**RE: Engineer's Certification for Vinyard and Associates Building, Lot 39, Richfield
Business Park (C17/D2A18) Engineer's Stamp Dated 5/19/97.**

RE: GRADING AND DRAINAGE PLAN FOR VINYARD & ASSOCIATES BUILDING
(C17/D2A18) SUBMITTED FOR SO 19 AND BUILDING PERMIT APPROVAL,
ENGINEER'S STAMP DATED 9/13/96.

**RE: GRADING AND DRAINAGE PLAN FOR VINYARD & ASSOCIATES
BUILDING (C17/D2A18) SUBMITTED FOR BUILDING PERMIT
APPROVAL, ENGINEER'S STAMP DATED 7/22/95.**

Re: Vinyard and Associates (C17/D2A18)

GRADING & DRAINAGE PLAN

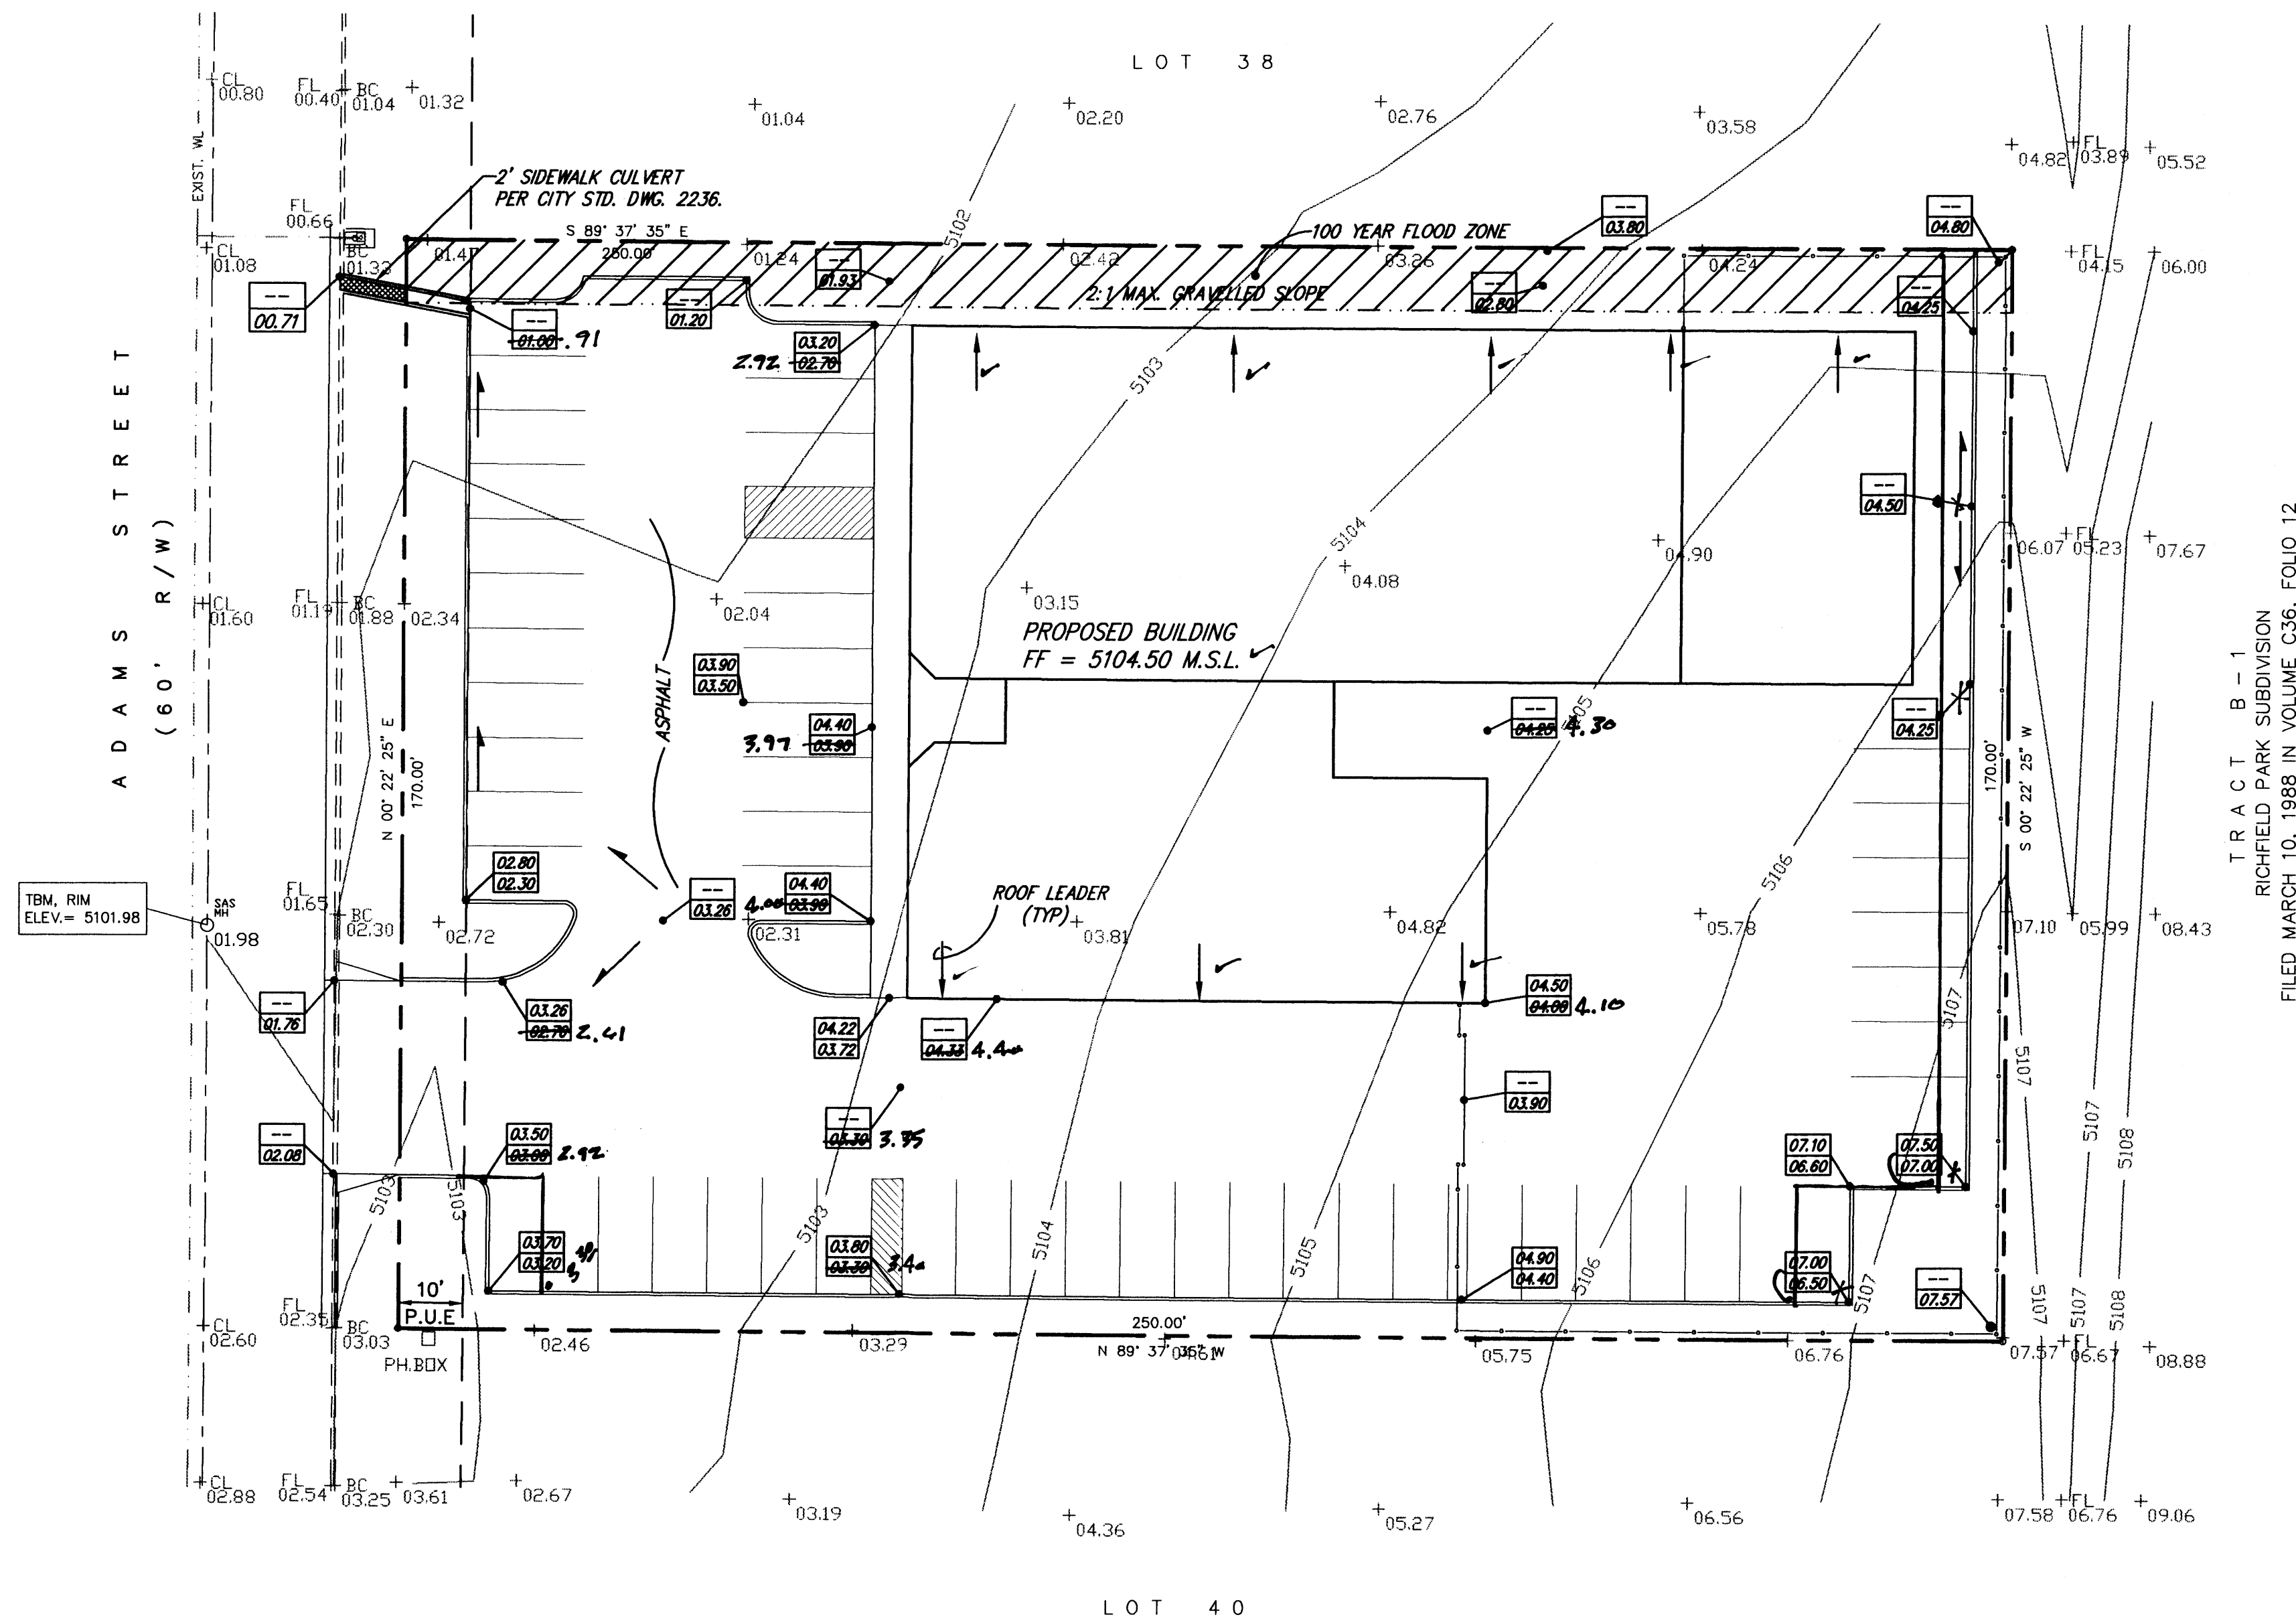
In response to your letter dated 7/19/95:

1. *Flood Zone is shown on drawing and note is removed.*
2. *Swale is for the purpose of catching the roof drains. The 5' swale has capacity of 5 cfs vs. entire site flow of 3.7 cfs.*
